30 Merrill Conditions of Site Plan Approval

Mon, Nov 28, 2016 at 2:01 PM

I've reviewed the updated plans, and can provide the following comments. Tom will need to weigh in on a couple of them.

2 FIRST FLOOR
SCALE: 1/4" = 1'-0"

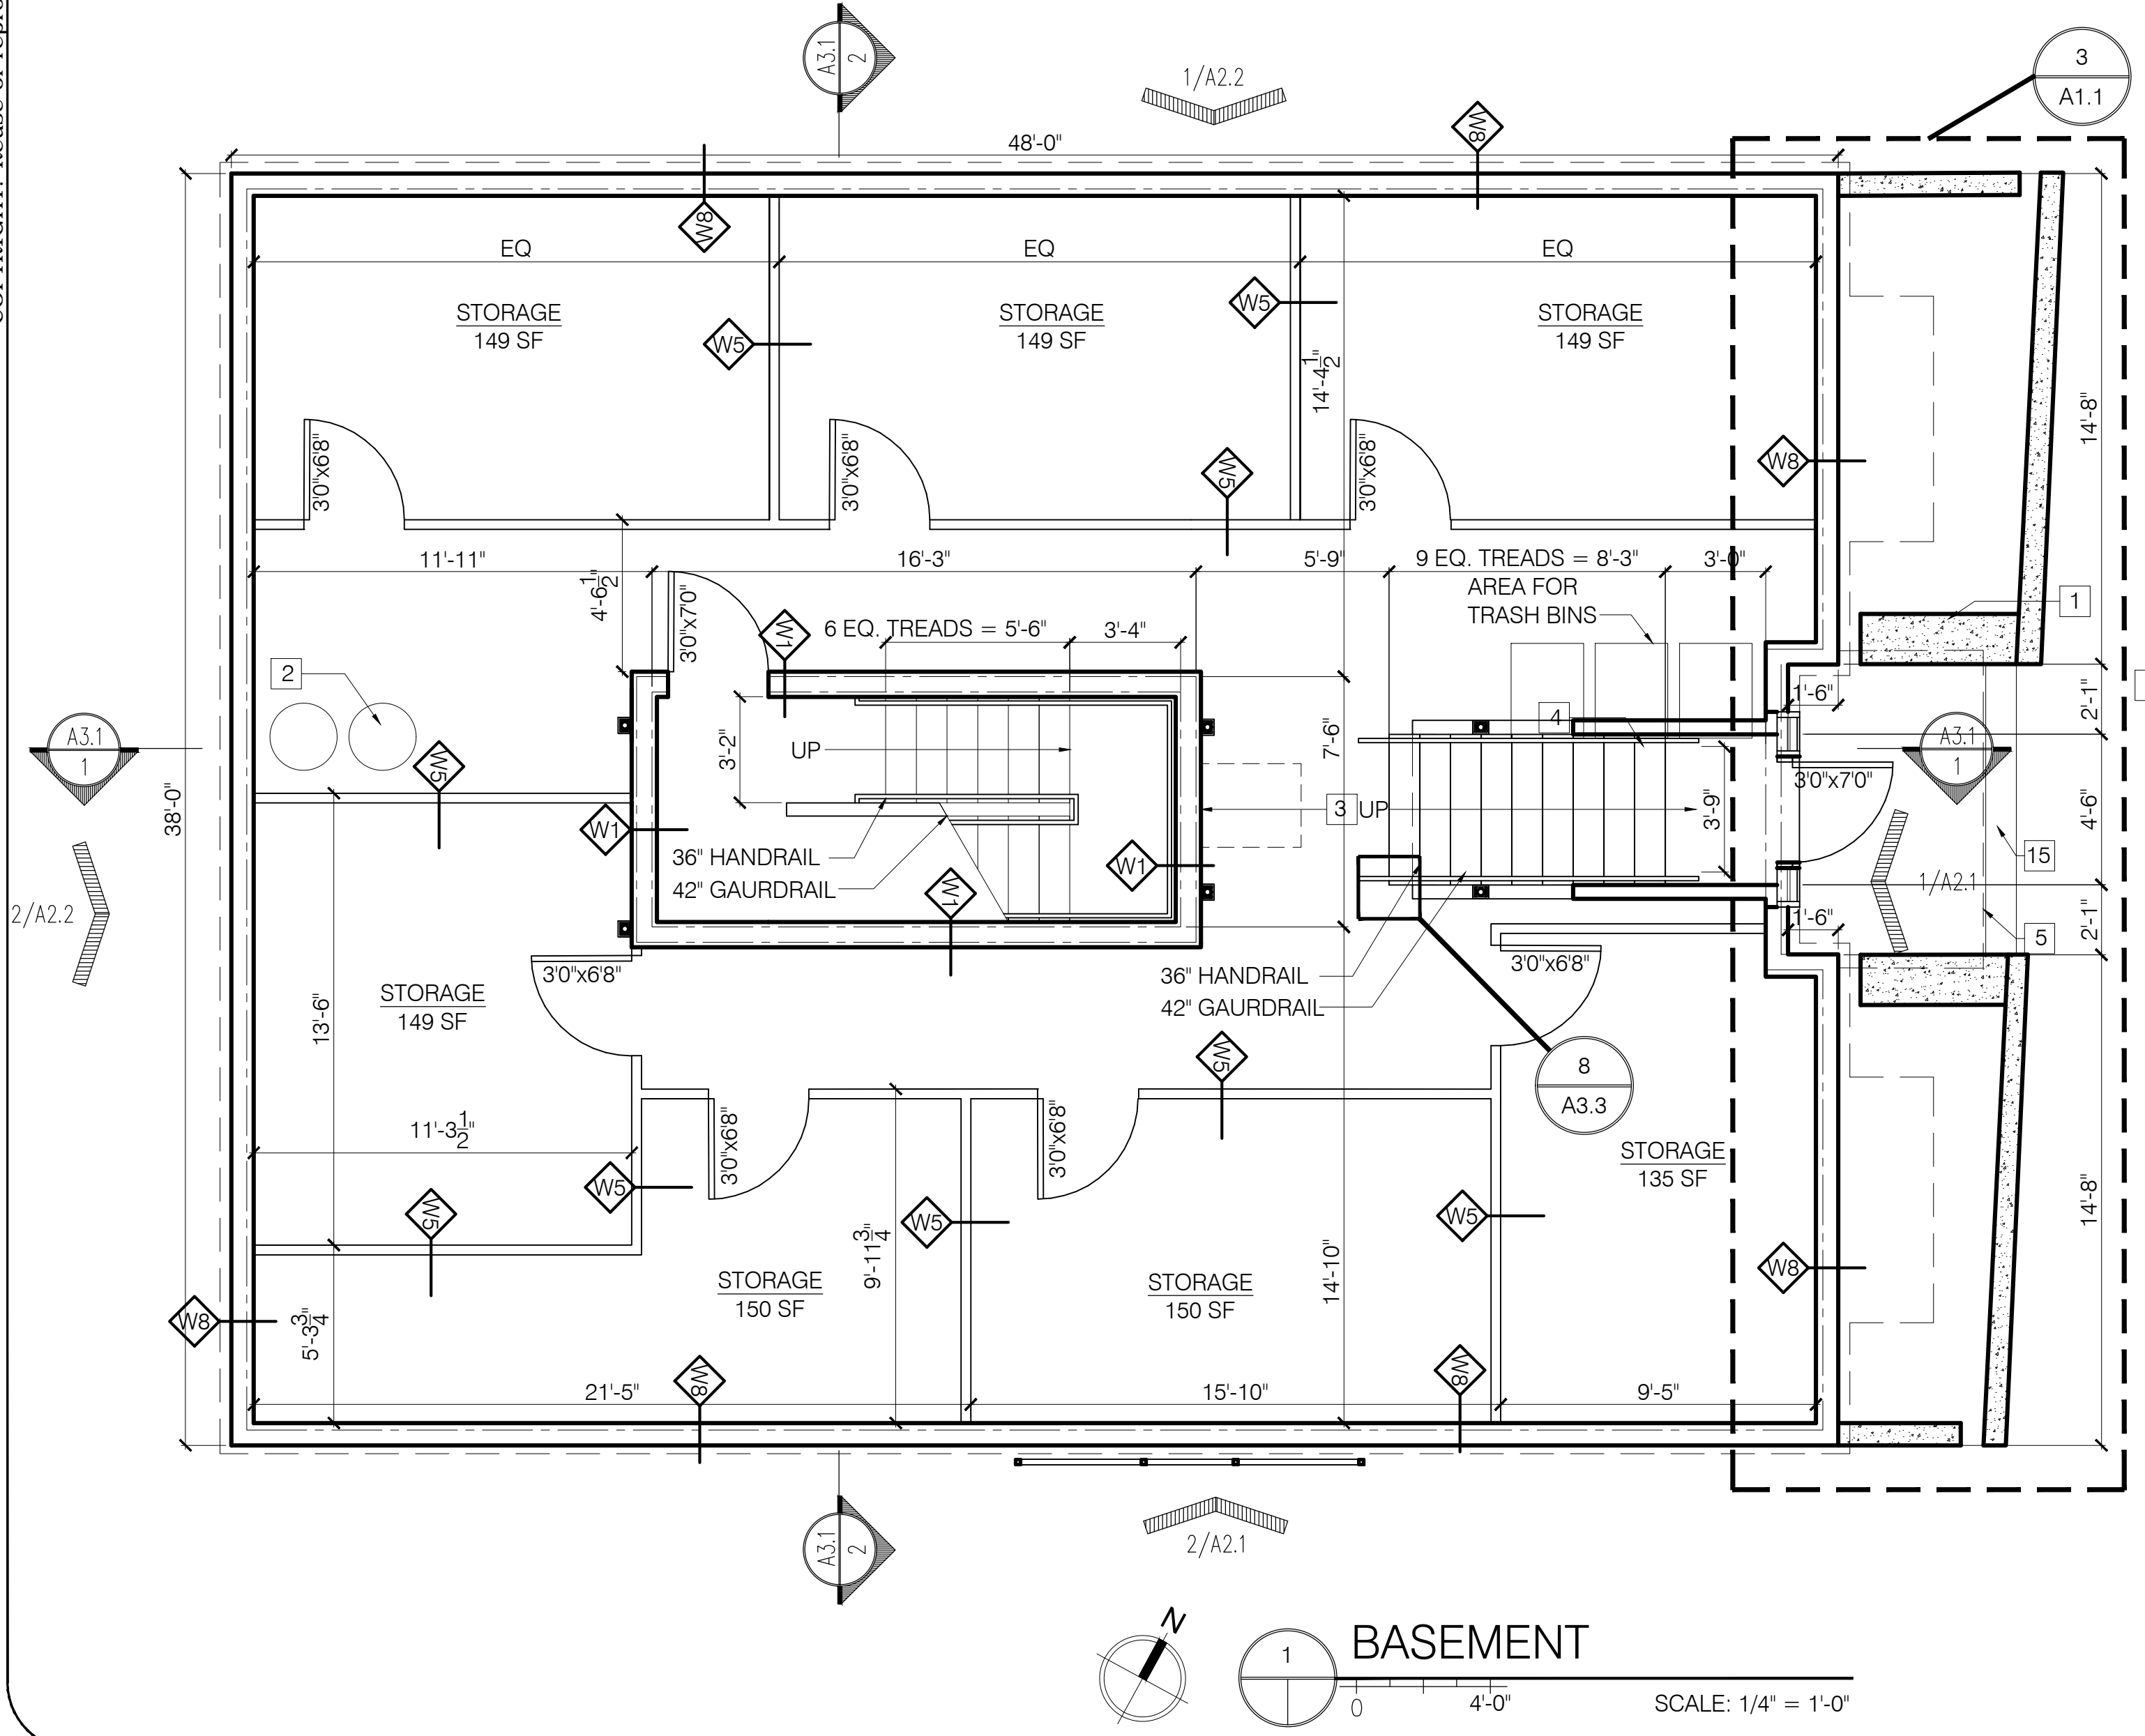
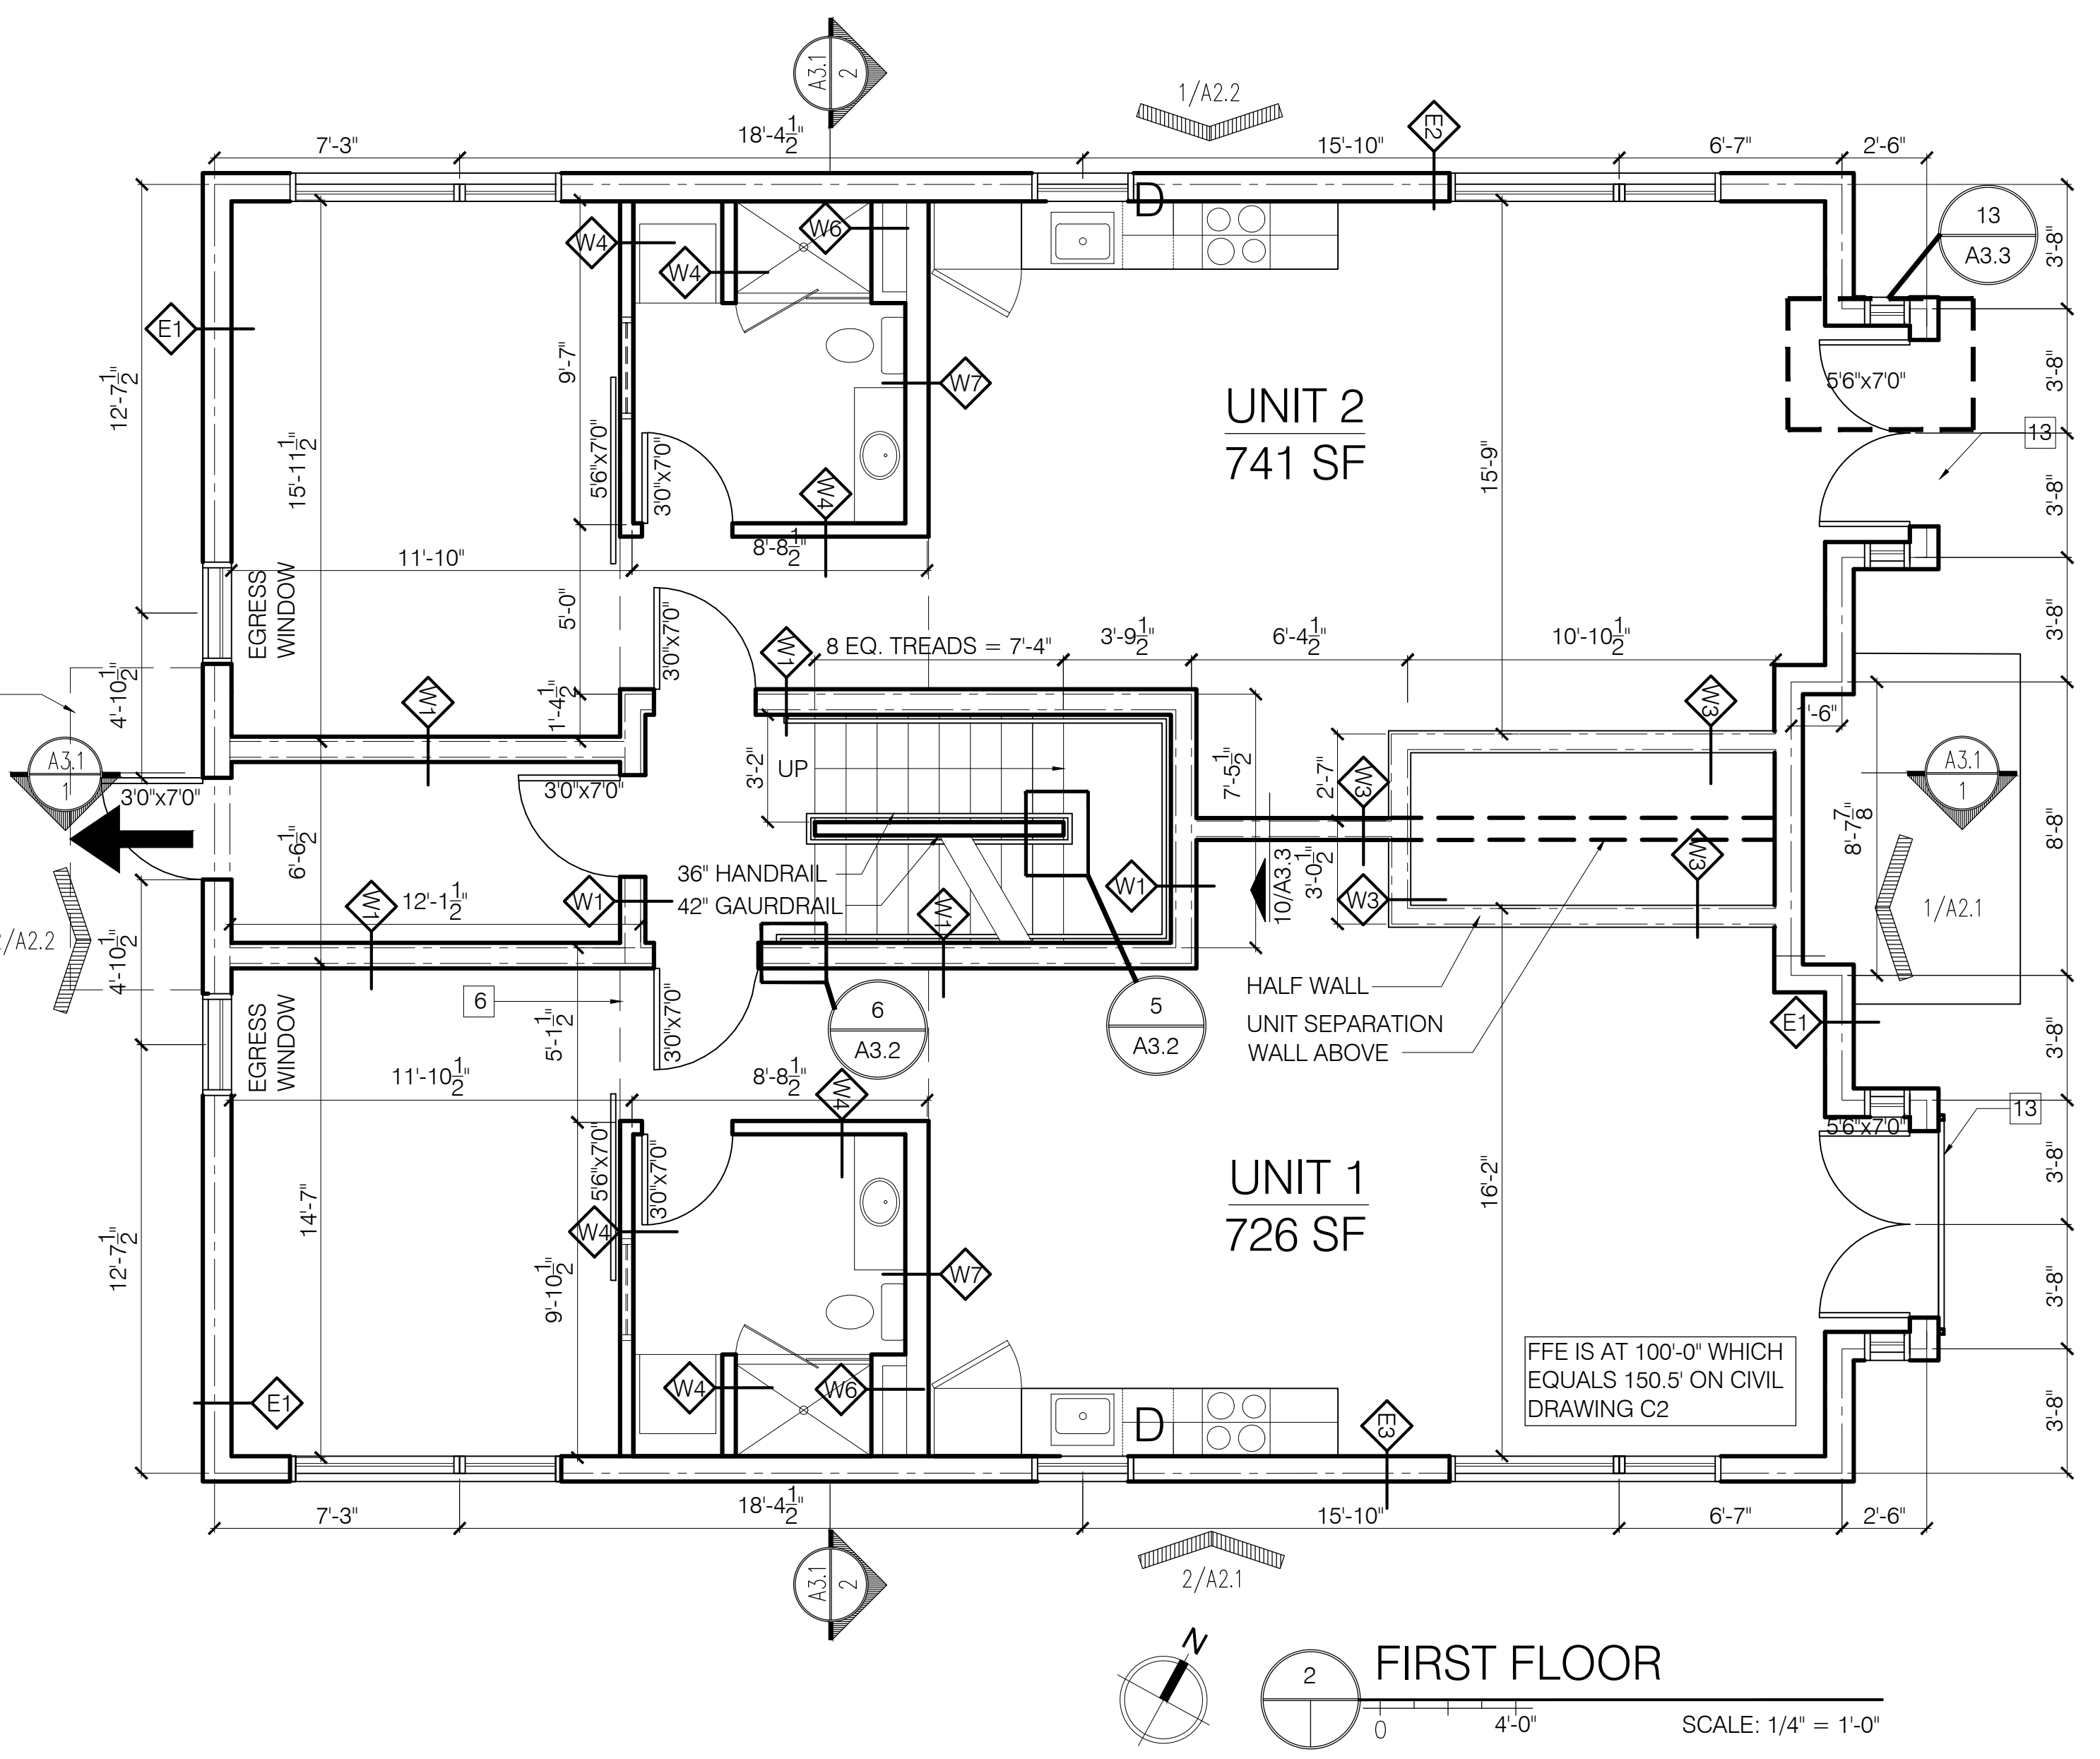
1.c. The site plan includes a couple of lines at the front entrance that could represent steps, but they are not labeled, and the grading plan does not reflect steps. They do show concrete planters around the front of the building that may also be the benches that are referred to. The architectural details include two different stair riser/tread details. These are both more extensive than would be at this front step though. Based on the renderings, it looks like these will be just granite steps. More information on what we're looking at would be helpful here.
